WINDERMERE

PRELIMINARY PLAN

EL PASO COUNTY, COLORADO

PRELIMINARY PLAN

PP02

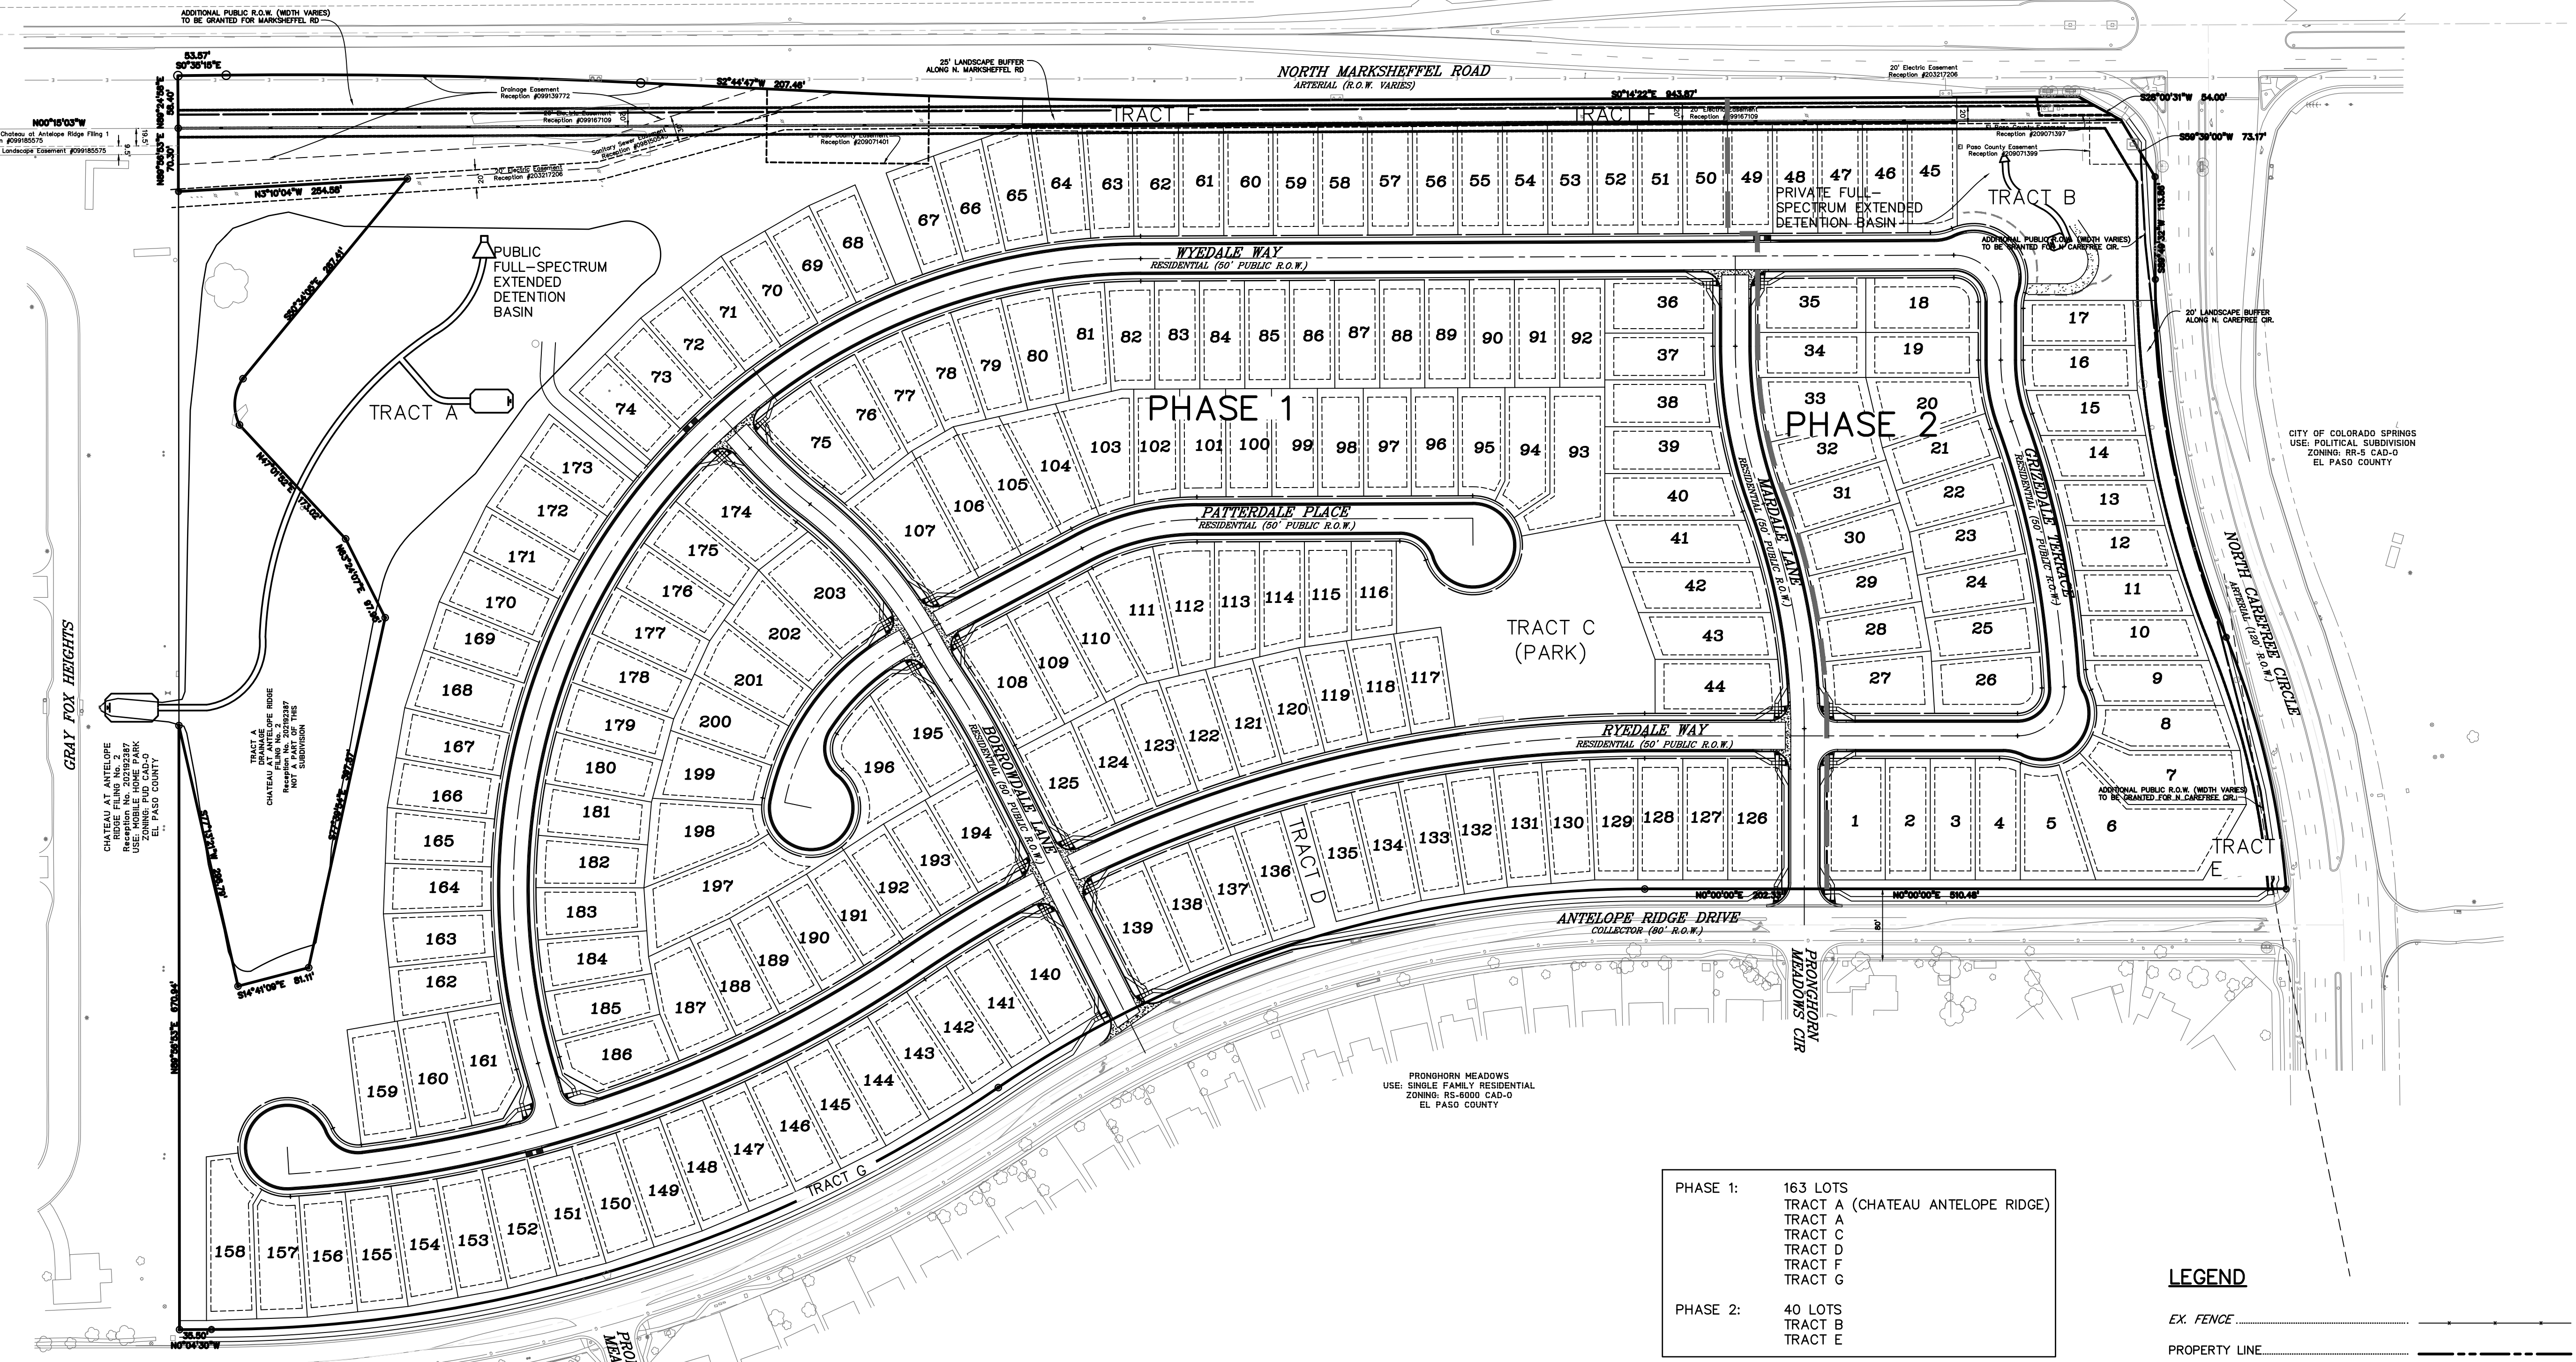
label all easements

Show ROW dedication and preservation.

# PP01

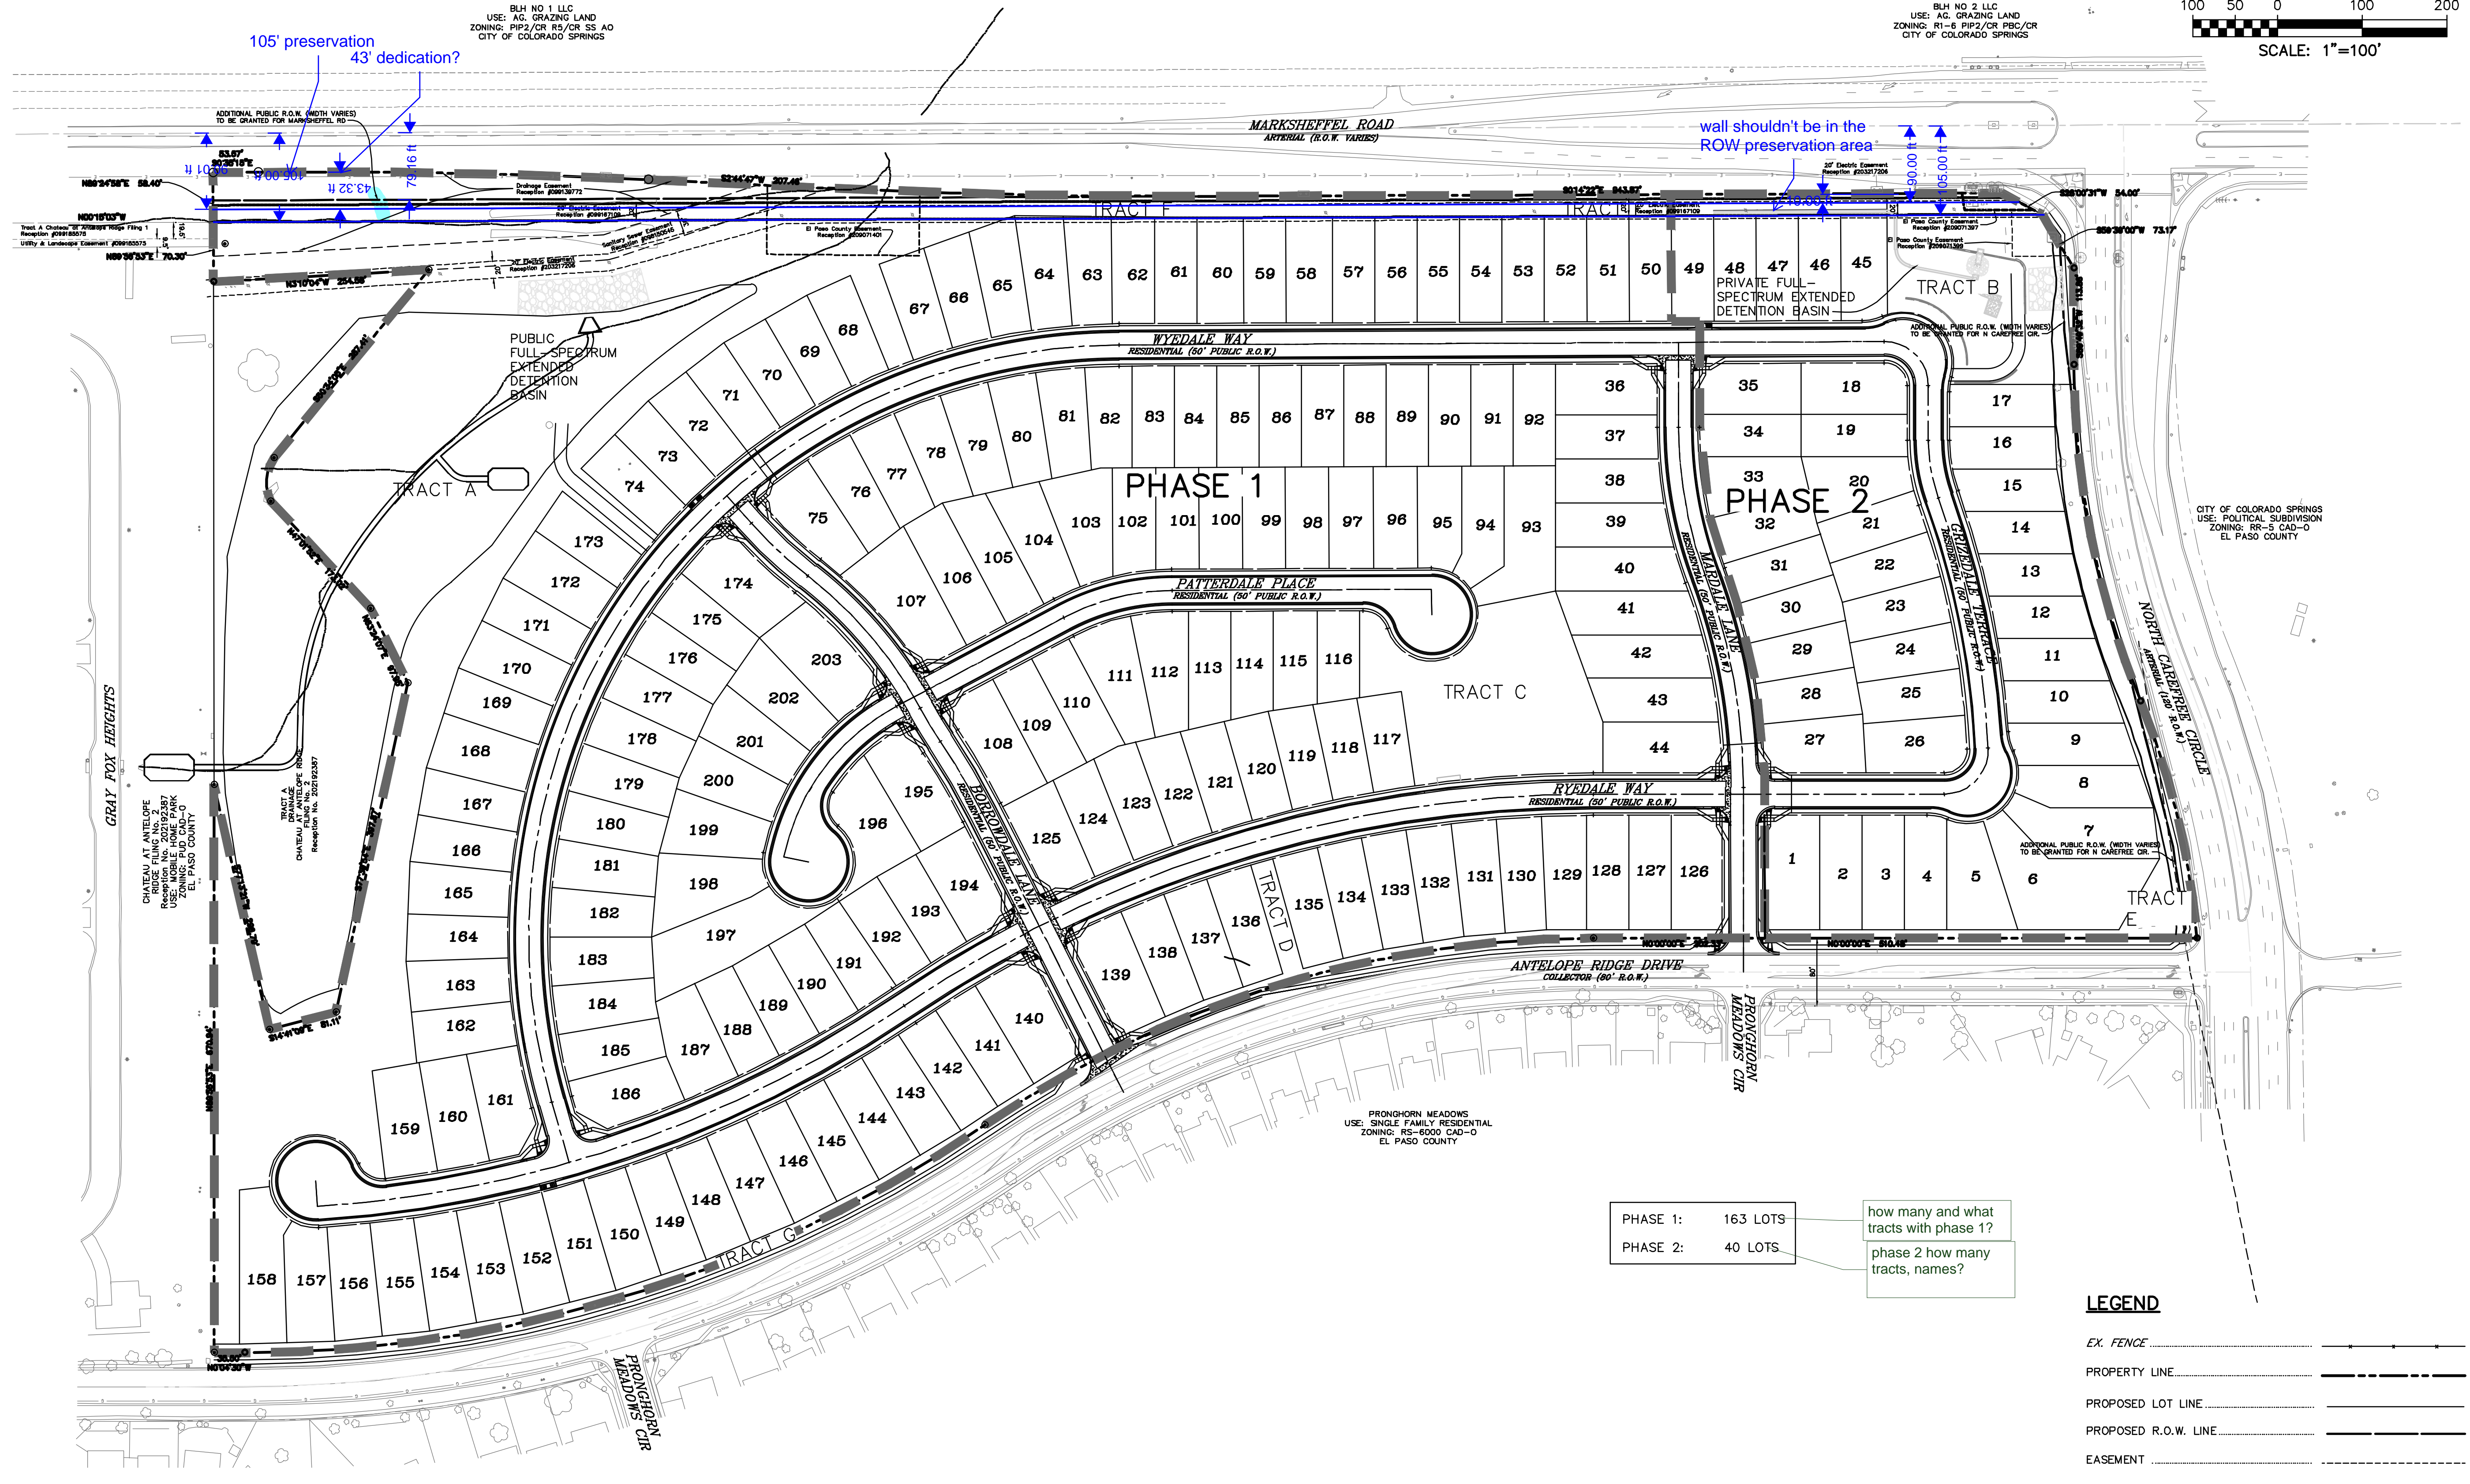
Provide all Preliminary Plan checklist items.

all check list items should be on sheets 2-5 (Checklist uploaded) A full review will occur when resubmitted.

Provide the detail of the sound wall (study identified 8-feet, Code allows for 7- feet) a 7' wall & a combination of plantings may be necessary. Have noise provider determine if a combination is necessary in lieu of 8-foot wall. Show wall on prelim plan map.

Customize Notes and add- Identify lots impacted. Geo report needs to be submitted

Sub-regional pond and the small pond?????

how will this be enforced; The County cant enforce that... provide clear direction. Landscaping is not allowed in the ROW w/o a landscape license agreement (what is the justification to have one-unlikely here)?

- CONTOUR INTERVAL SHOWN ON PLAN 2'.
- PUBLIC UTILITY/DRAINAGE EASEMENTS SHALL BE PROVIDED ON ALL LOTS AS FOLLOWS:
 FRONT: TEN (10) FEET
 SIDE: FIVE (5) FEET
 REAR: TWENTY-FIVE (25) FEET
 SUBDIVISION PERIMETER: 220'
 No- This cant be.
 25 drainage easement is not correct on rear lots? The setback is as much.
 delete- you are paying fees per LOLfor correct LOL

Are Tracts F and G for ROW?

PRELIMINARY  
SITE PLAN

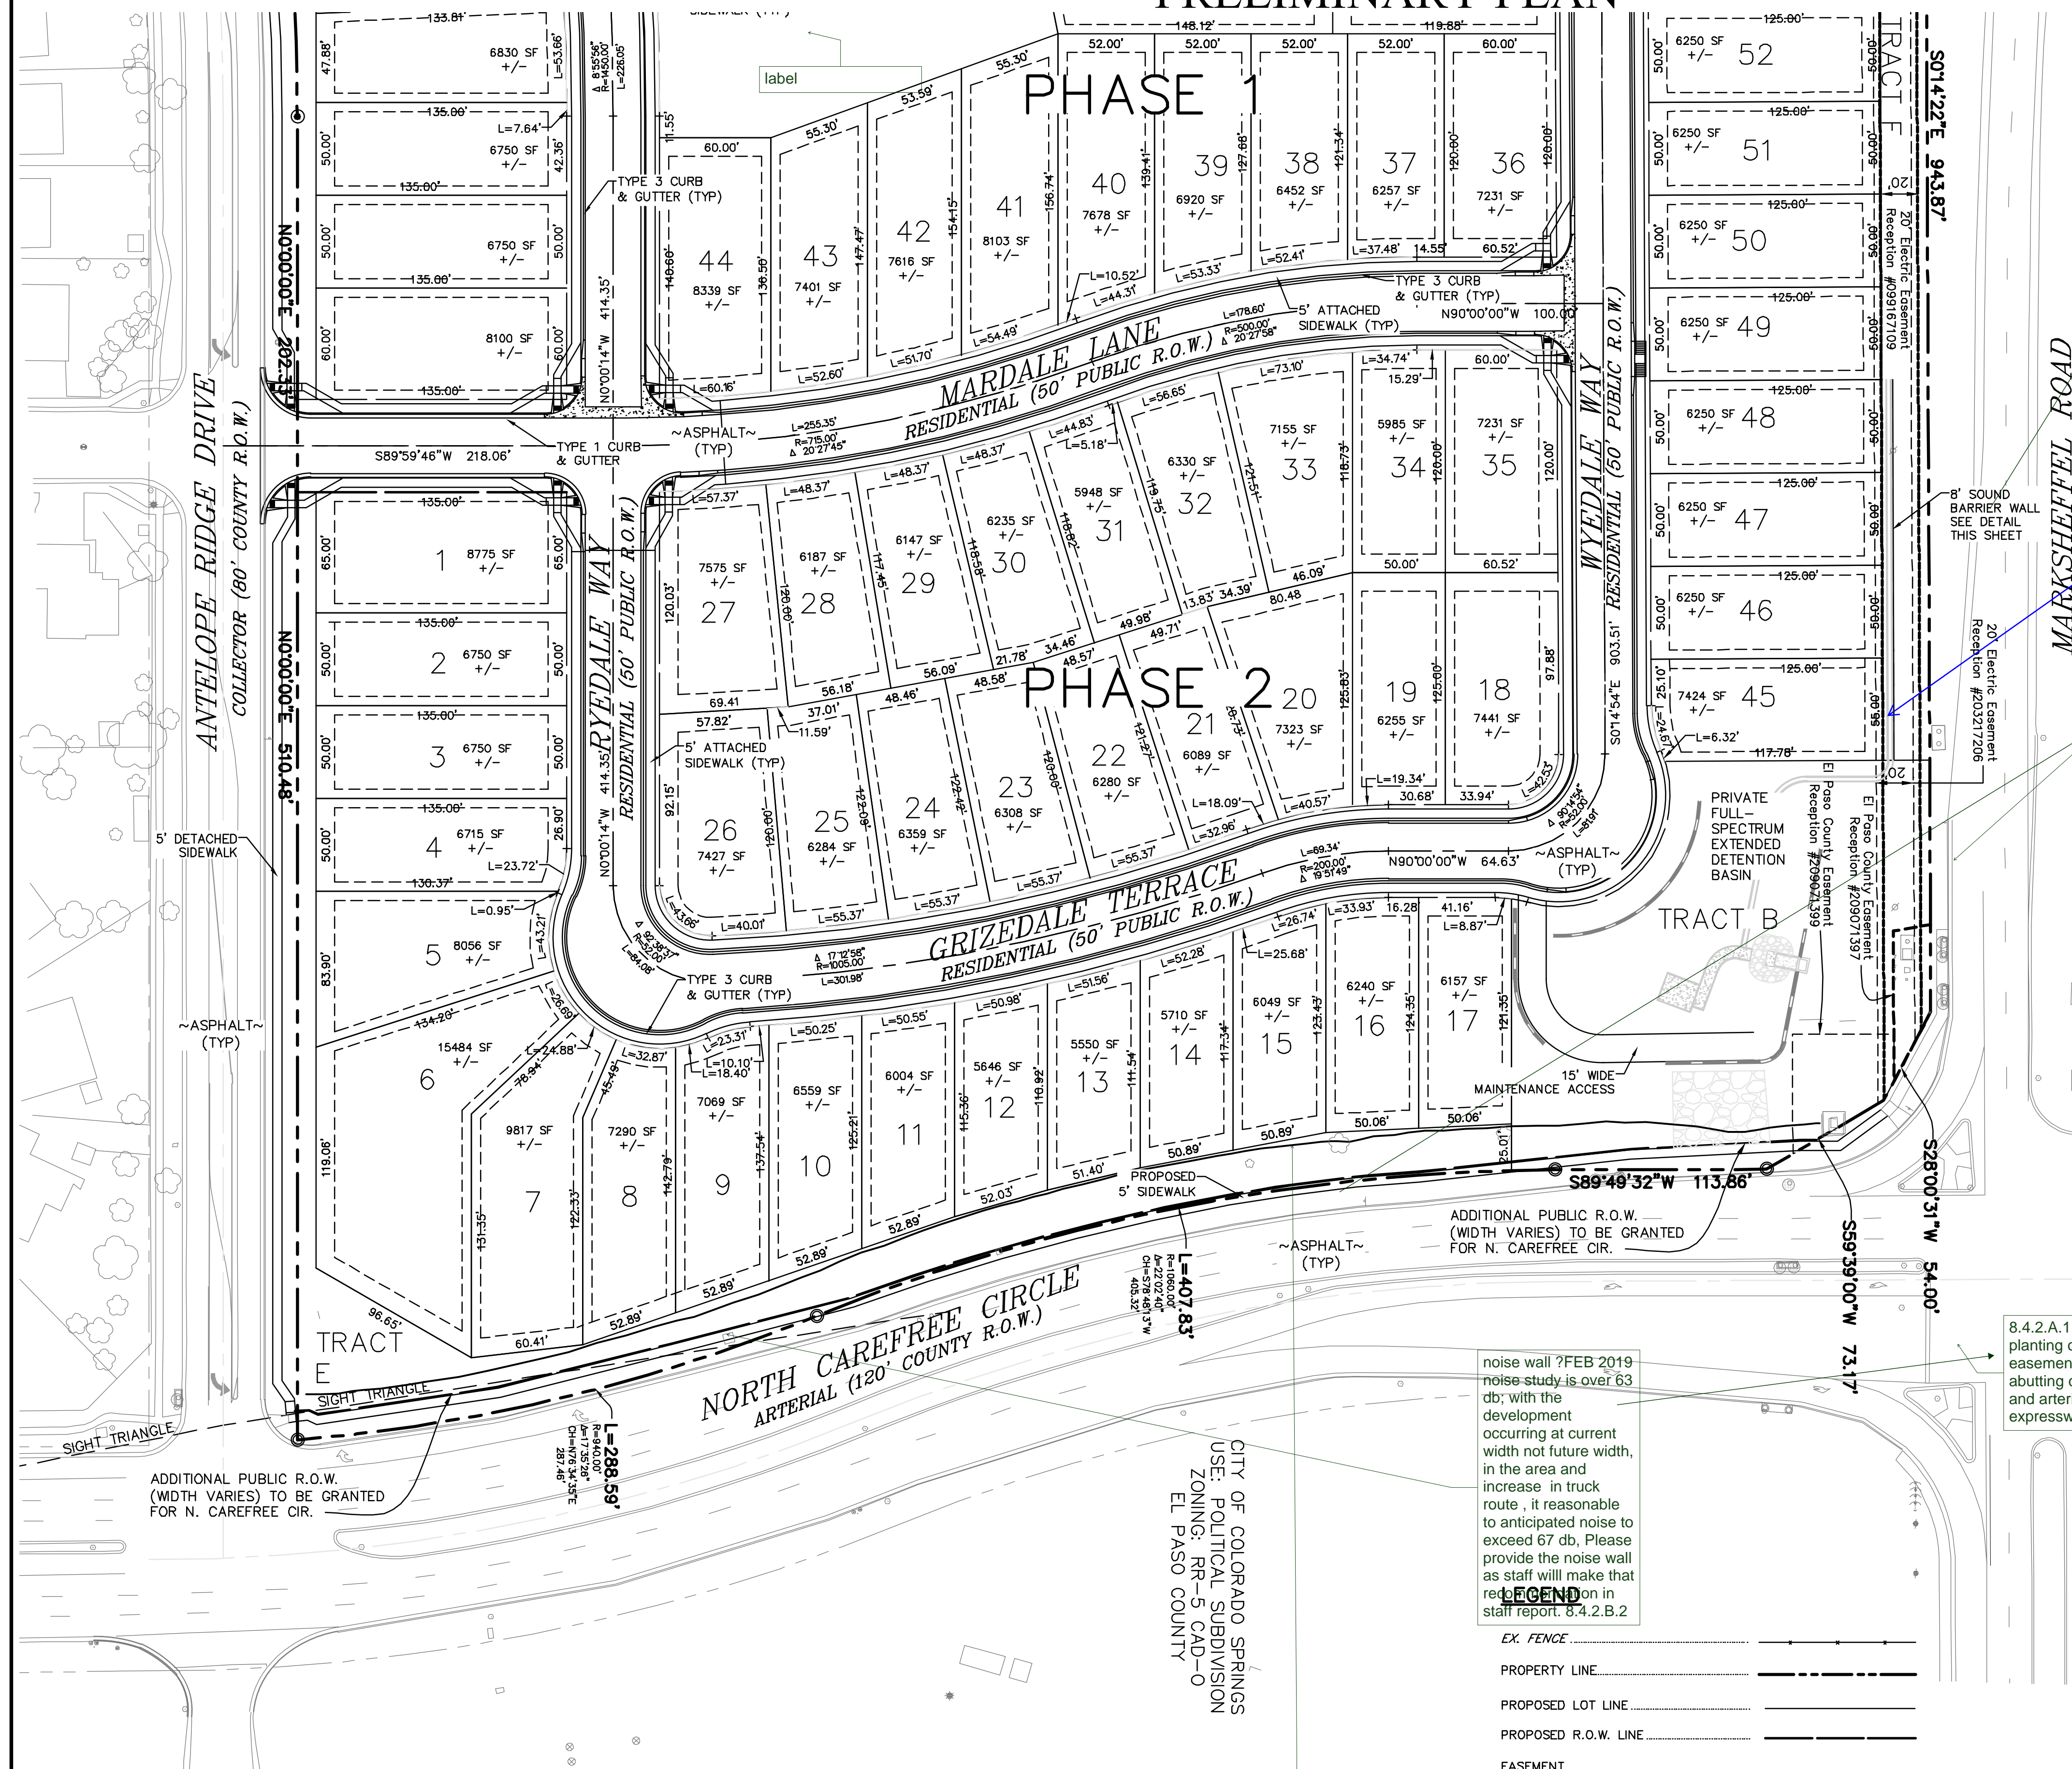
Provide additional ROW to accommodate sidewalk.

Show noise wall

Show sight distance lines.
